Retreat at TimberRidge

PLANNED UNIT DEVELOPMENT PLAN

DATE: 04-17-17
PROJECT MGR: J. HAYWARD
PREPARED BY: K. MARSHALL

COVER SHEET

**2**  
OF 4

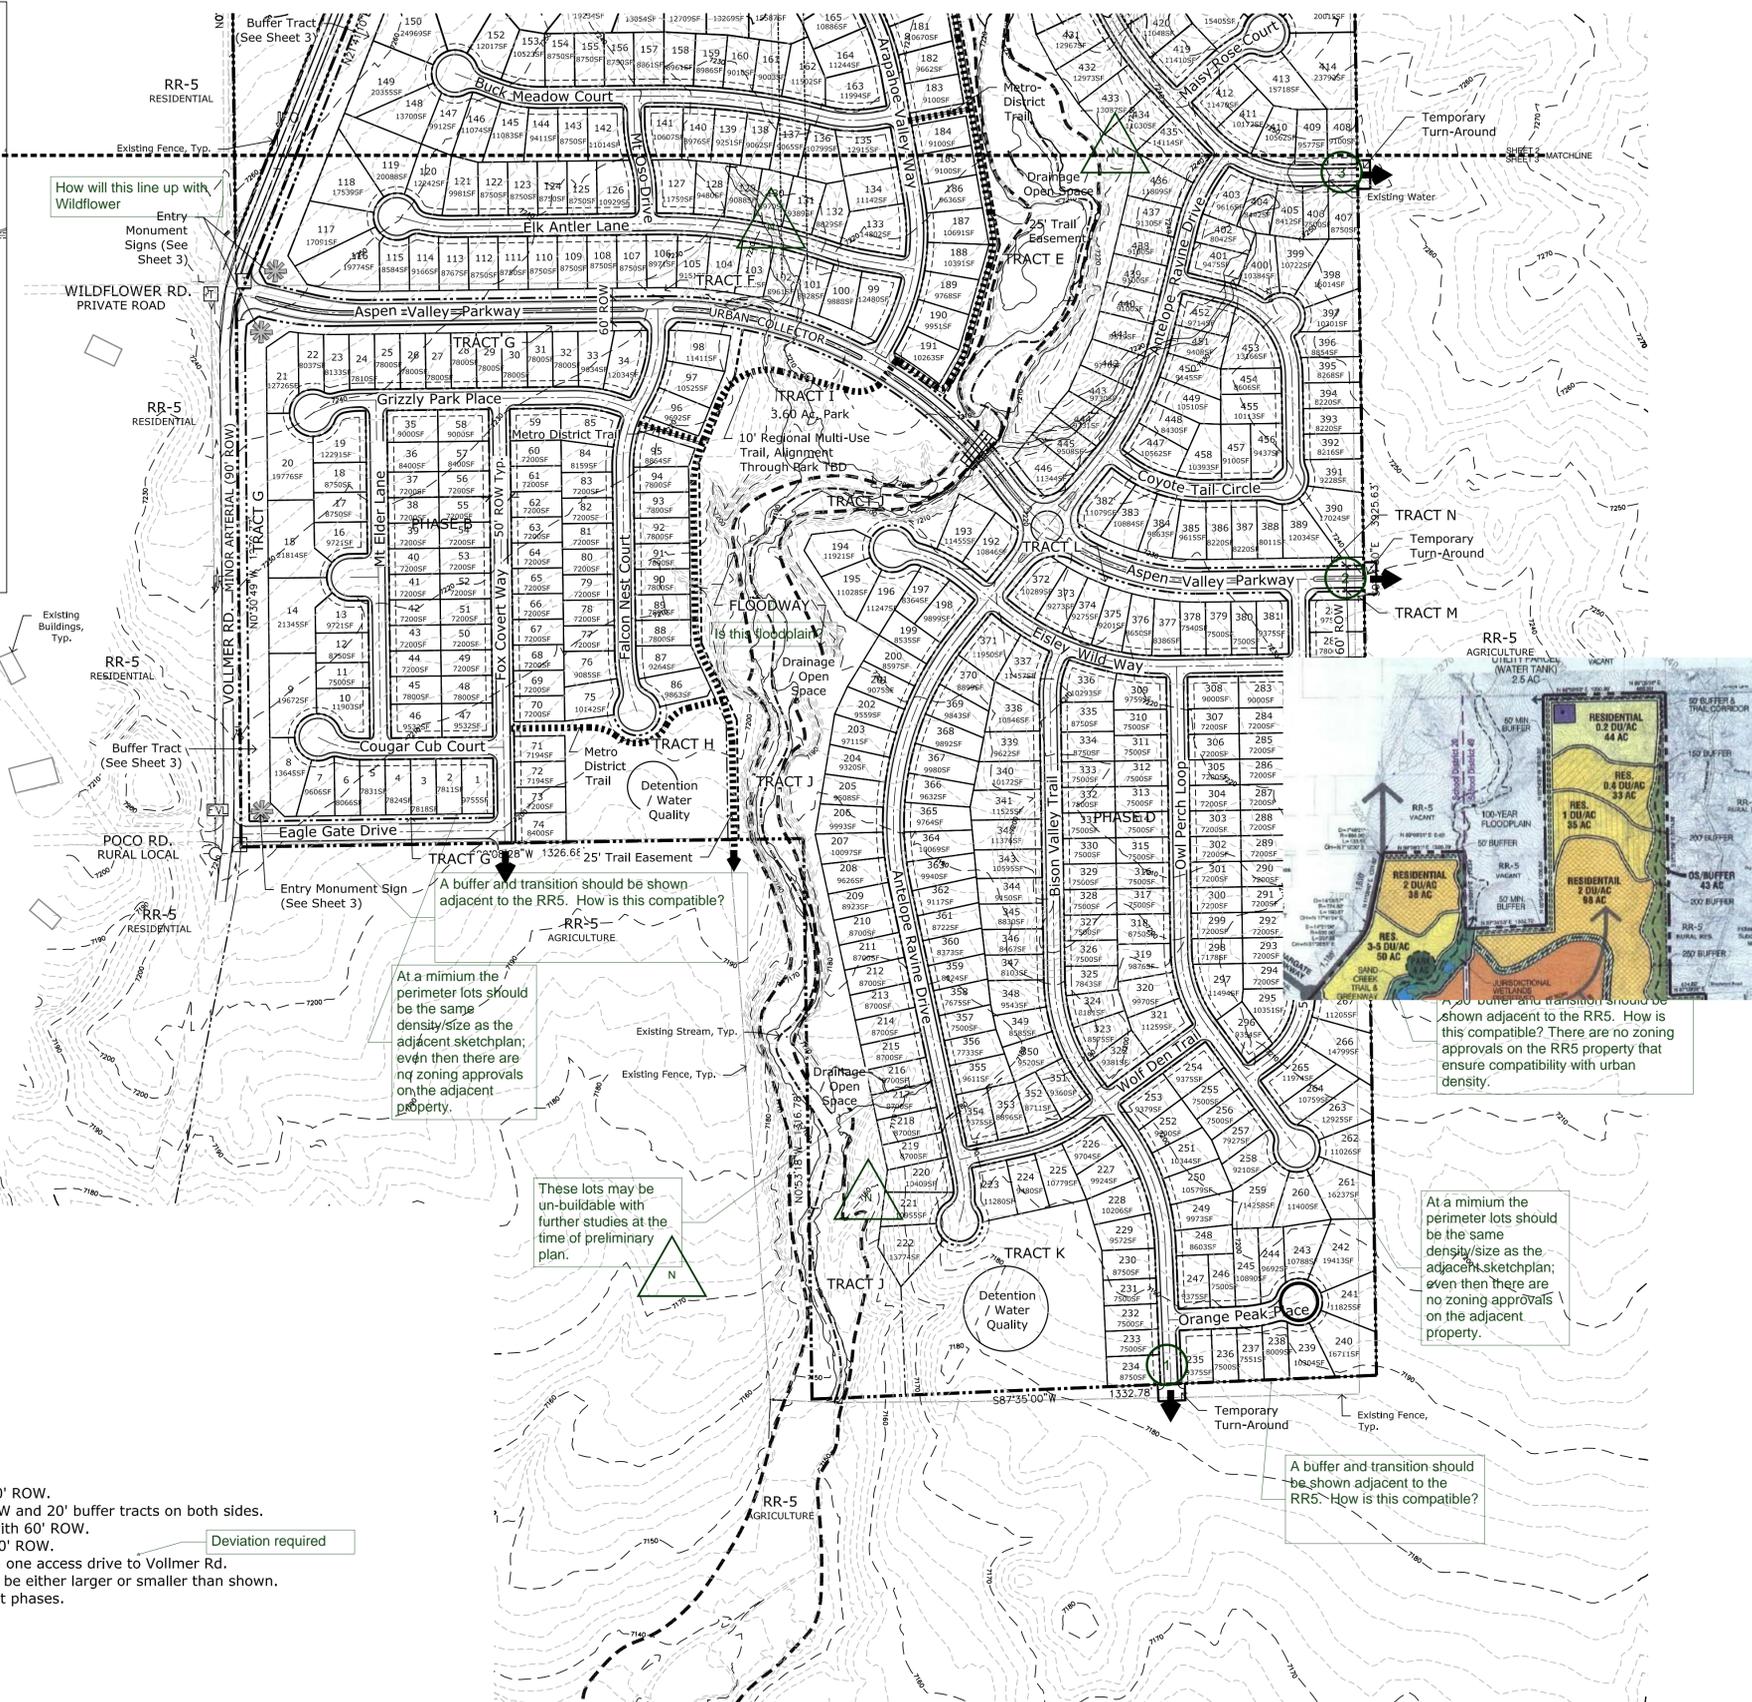
Please thicken the floodplain line. Lots can not be created if they are in the floodplain unless they are 2.5 acres or more pg 8-6.

This is not the current floodplain boundary

Is this to remain? Do you have have the rights to retain? Please provide the receipt that you have sent the information the the State Eng. (This is a different office than the water sufficiency office)

Do these require deviations or PUD modifications for the size?

Some lots repeat the numbering. They should be lots 1 through 100, etc... It is very difficult to see what is Parcel b,c,d,e, etc. boundary is.. Do you mean this to be groups of design standards? Please clarify and depict. Staff recommends removing the parcel label and identifying the lots by numeric value starting with 1 and ending with the last lot.

Will a public turn around be provided? How will plows turn around as they will not maintain the private easement. Provide documentation for right to use private property for a road for traffic generated from this development.

Include existing easement purposes in labels or note.

- Ensure that all street centerline radii, intersection spacing, roundabout size, required tangent lengths, etc. meet criteria. Without dimension labels these cannot be verified. Approval of the PUD development plan does not imply approval of any substandard design features that have not been specifically addressed.

Remove this floodplain, show only the current floodplain

Please see the plat naming standards- section 7.2.5. There should be tracts and lots. Phase lines could be included.

Add acreage and a note that any lot configuration may occur as long as a 5 acre lot size is met, setbacks are: use is: accessory uses are: etc...

Please place the distance, bearings, & dimensions on the boundary of this PUD. it is difficult to see the boundary of the PUD. Also identify the acreage or square feet of each tract and lot

Please orient the drawing to the north (up- see sheets 3 and 1) please and break into two sheets so plan is legible. It is very difficult to read the line work and labels etc....This has to be recored on 24x36 and should be legible.

OVERALL LANDSCAPE PLAN

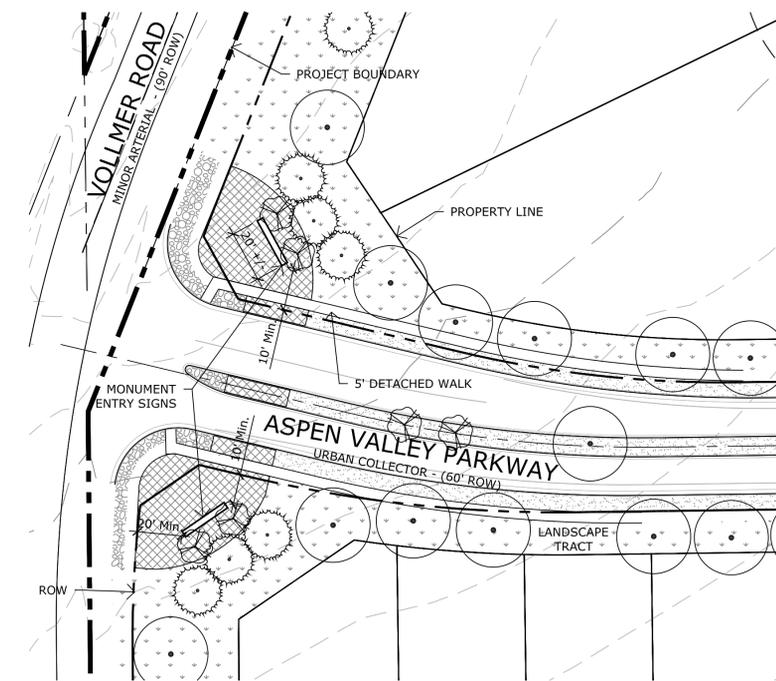
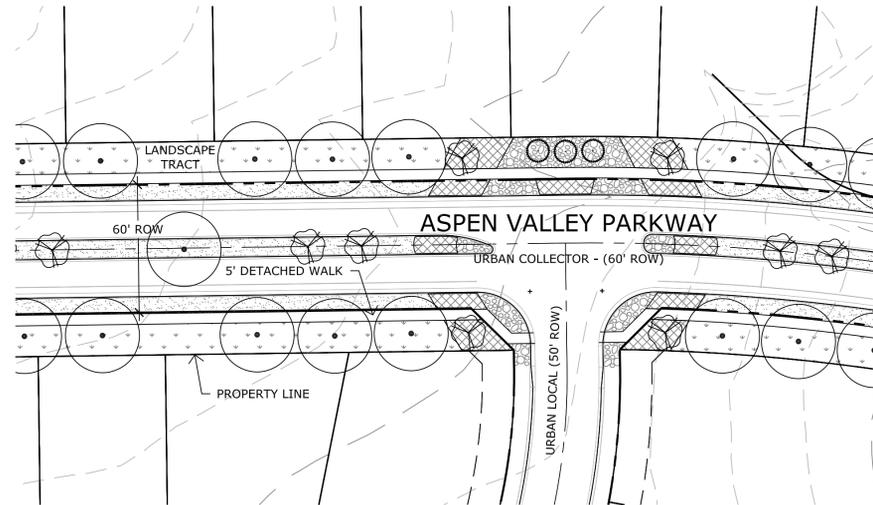
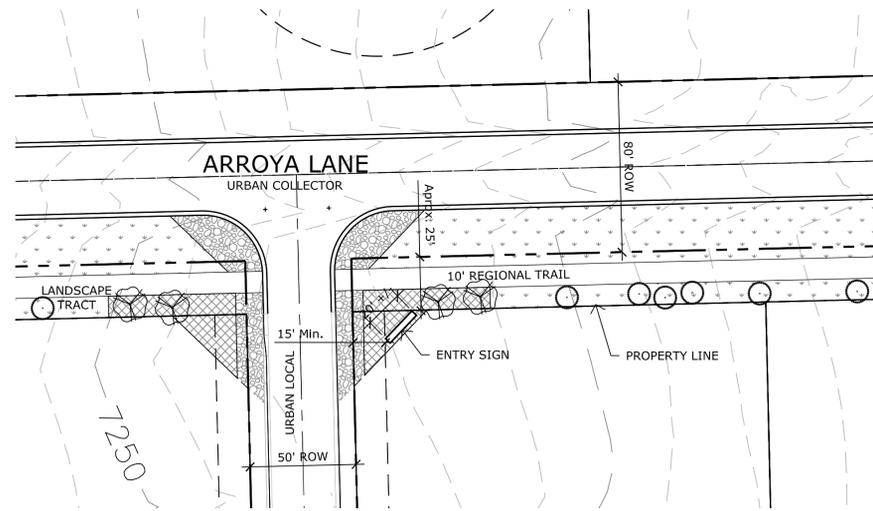
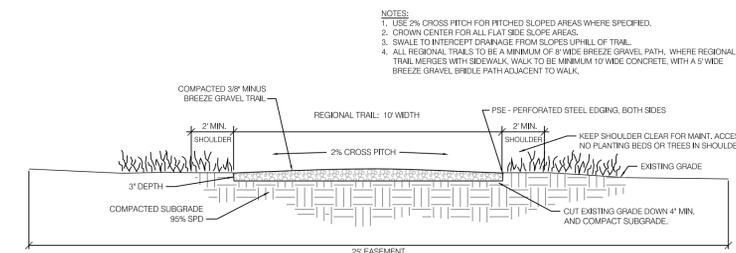
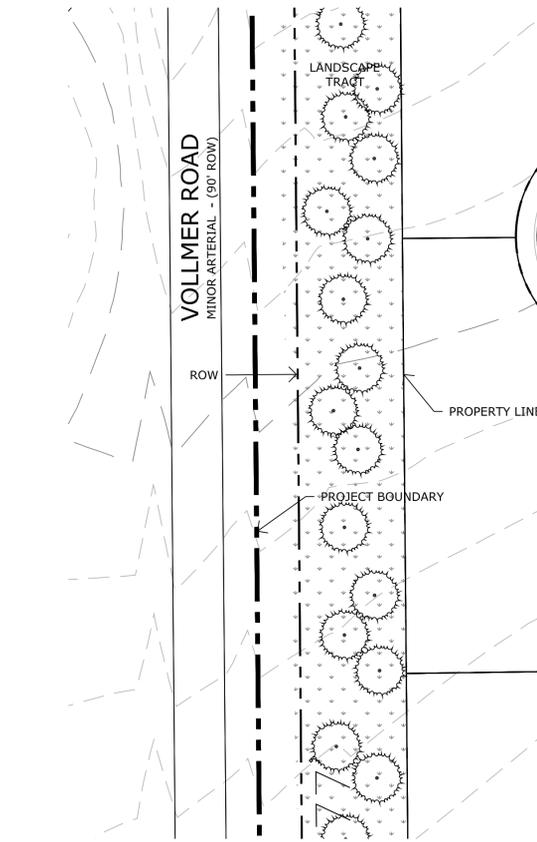
add PUD to all red clouds, this is not a preliminary plan- all the sheets are recorded and compose the PUD Development Plan
